Ribble Valley Borough Council
Housing & Development Control

Application no: **3/2023/0032**

Address: **Fair View Pendleton Road Wiswell BB7 9BU**

Proposal: **Proposed two-storey side extensions, new detached garage/carport and new porous finish to existing driveway.**

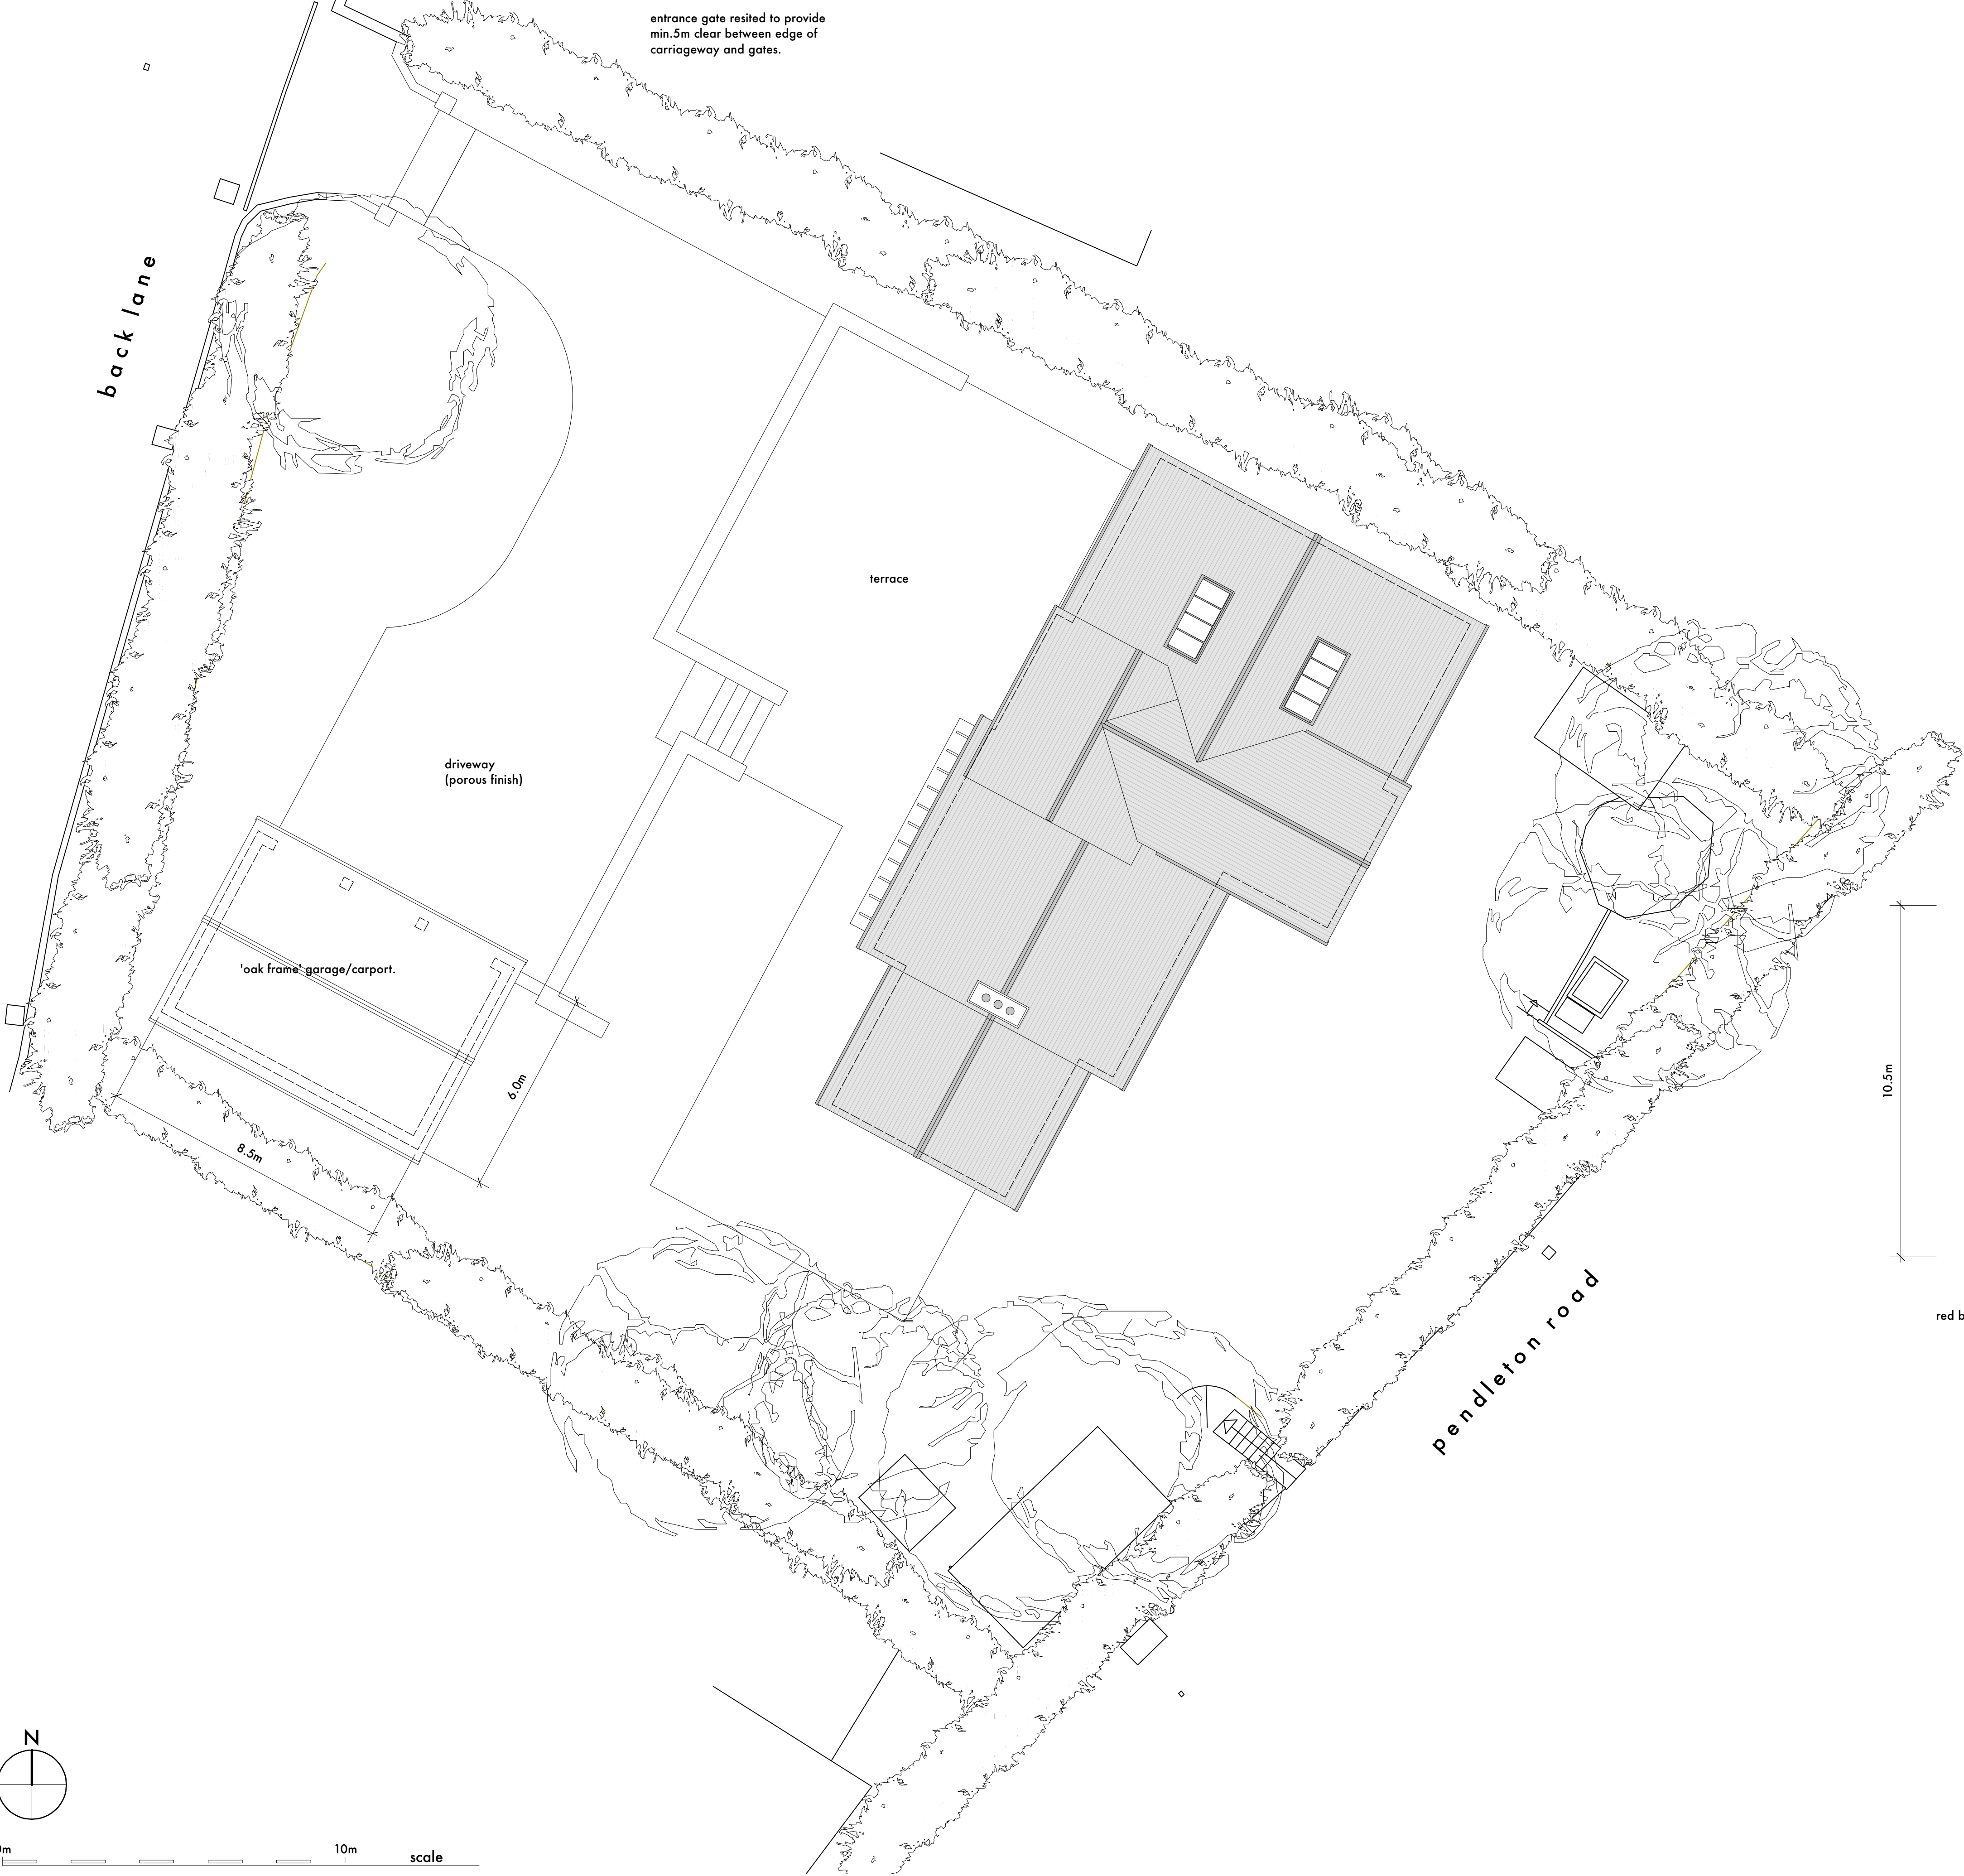
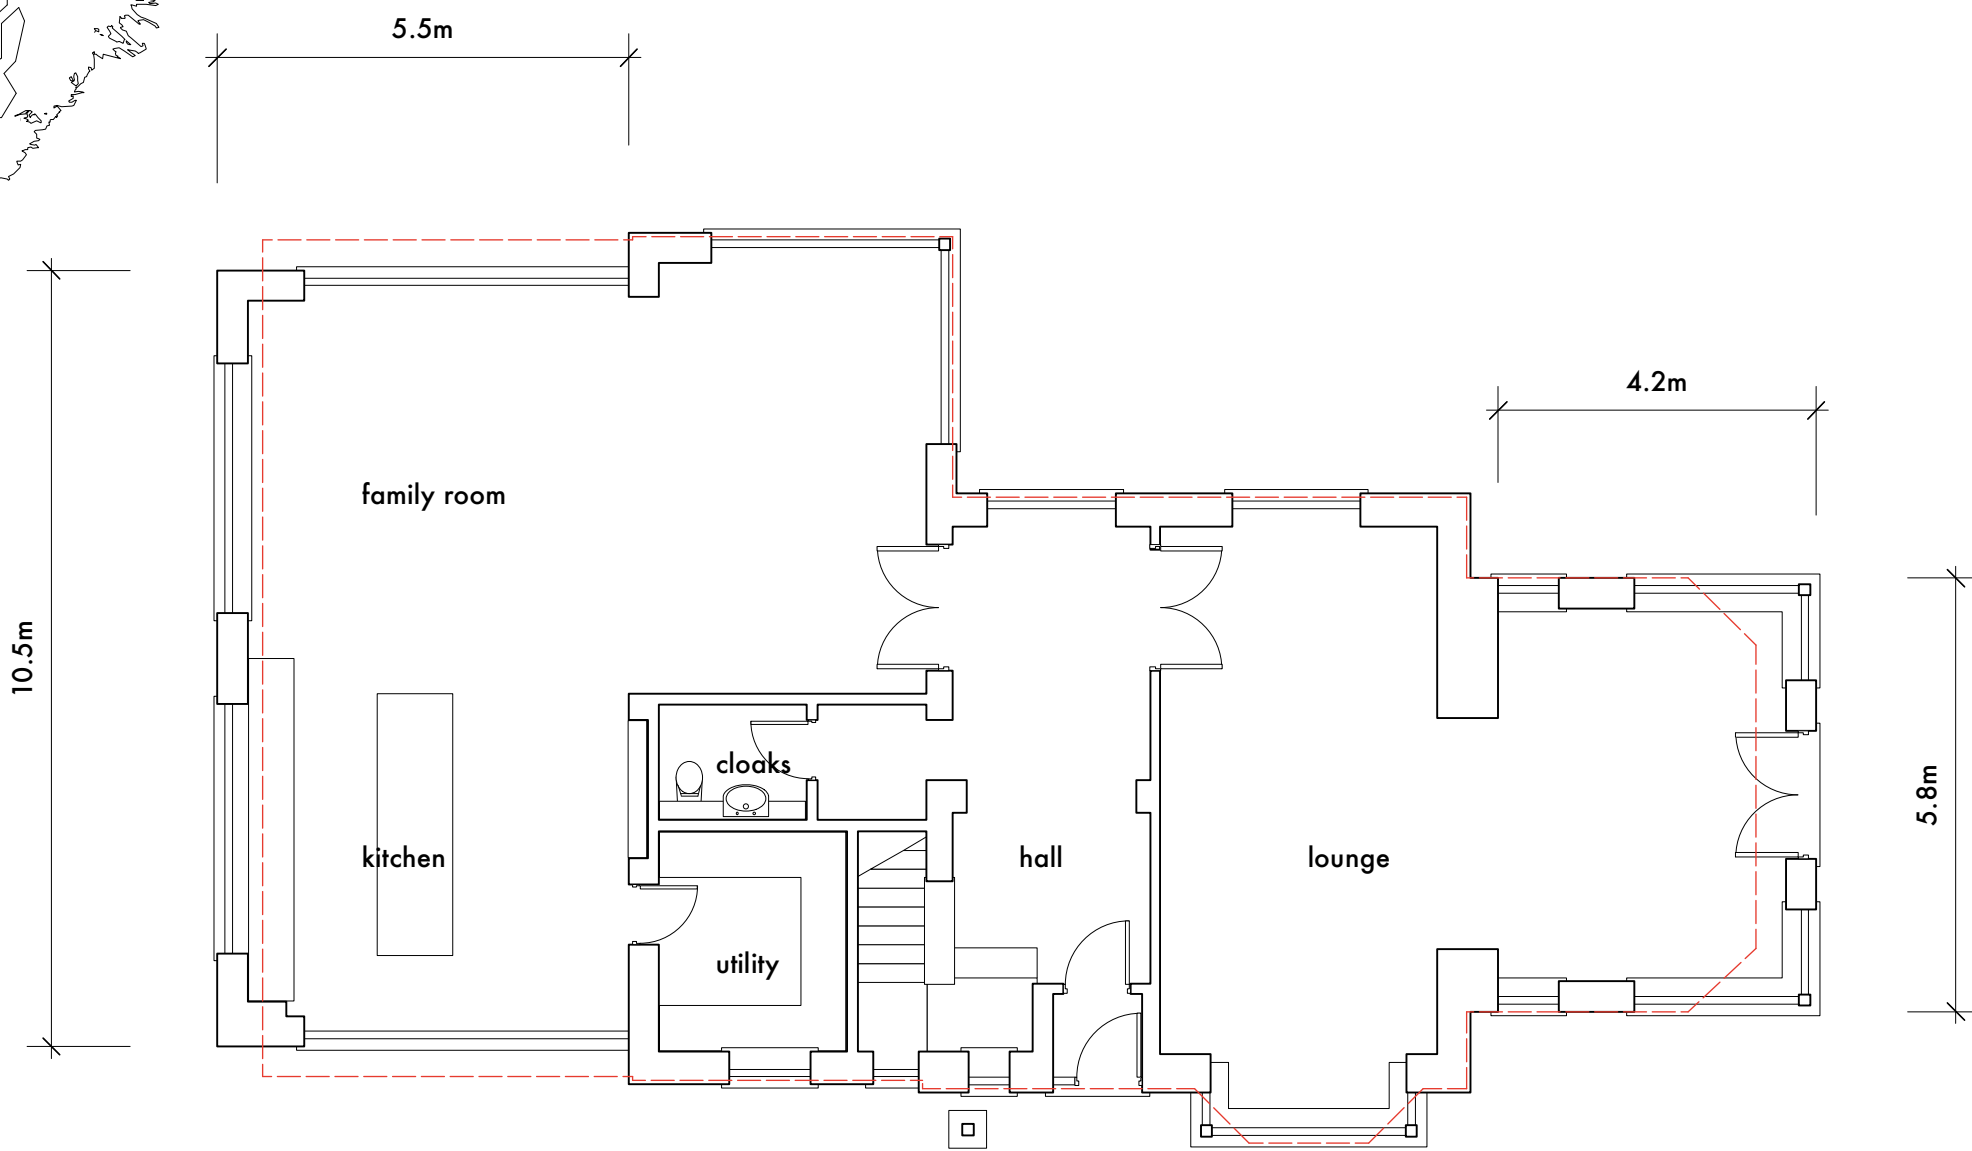
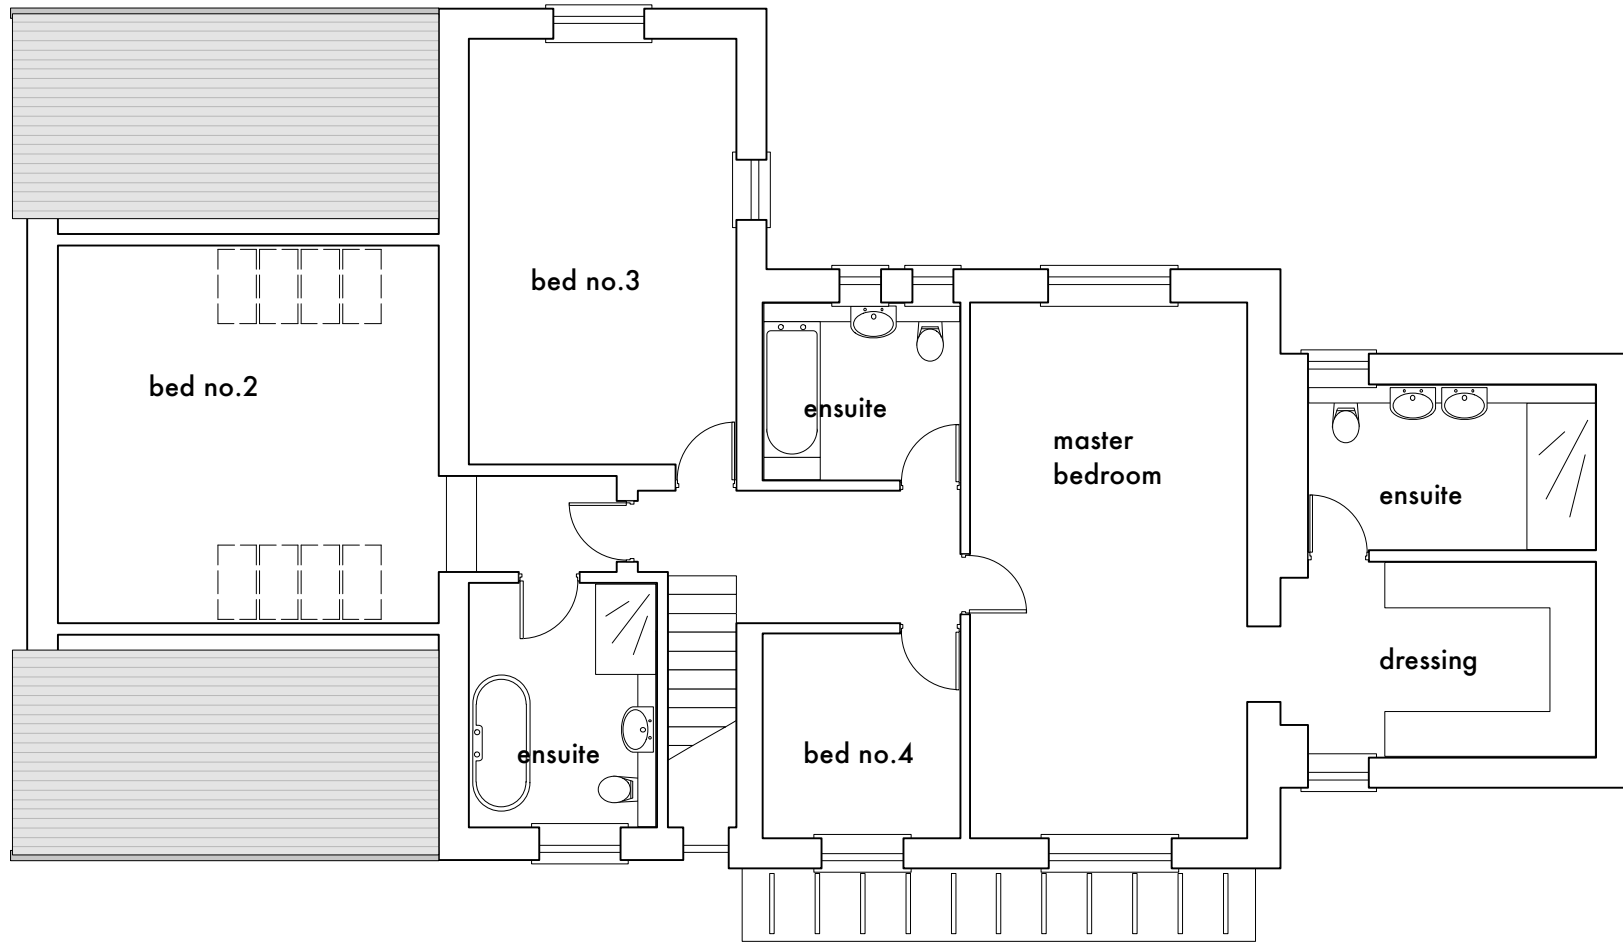
The LHA have reviewed Stanton Andrews drawing number pl.10 Rev B titled "Proposed Site Plan and Floor Plans" and are aware that the site can provide a minimum of 3 car parking spaces for the 4-bed dwelling which complies with the LHAs guidance.

The LHA are also aware that the site access will remain unaltered following the proposal but will condition that the access is adequately surfaced for a minimum of 5m behind the public highway.

1. The development hereby permitted shall not be occupied until such time as the parking and turning facilities have been implemented in accordance with Stanton Andrews drawing number pl.10 Rev B. Thereafter the onsite parking provision shall be so maintained in perpetuity.

2. The development hereby permitted shall not be occupied until such time as the access drive (and any turning space) has been surfaced with tarmacadam, or similar hard bound material (not loose aggregate) for a distance of at least 5 metres behind the highway boundary and, once provided, shall be so maintained in perpetuity.
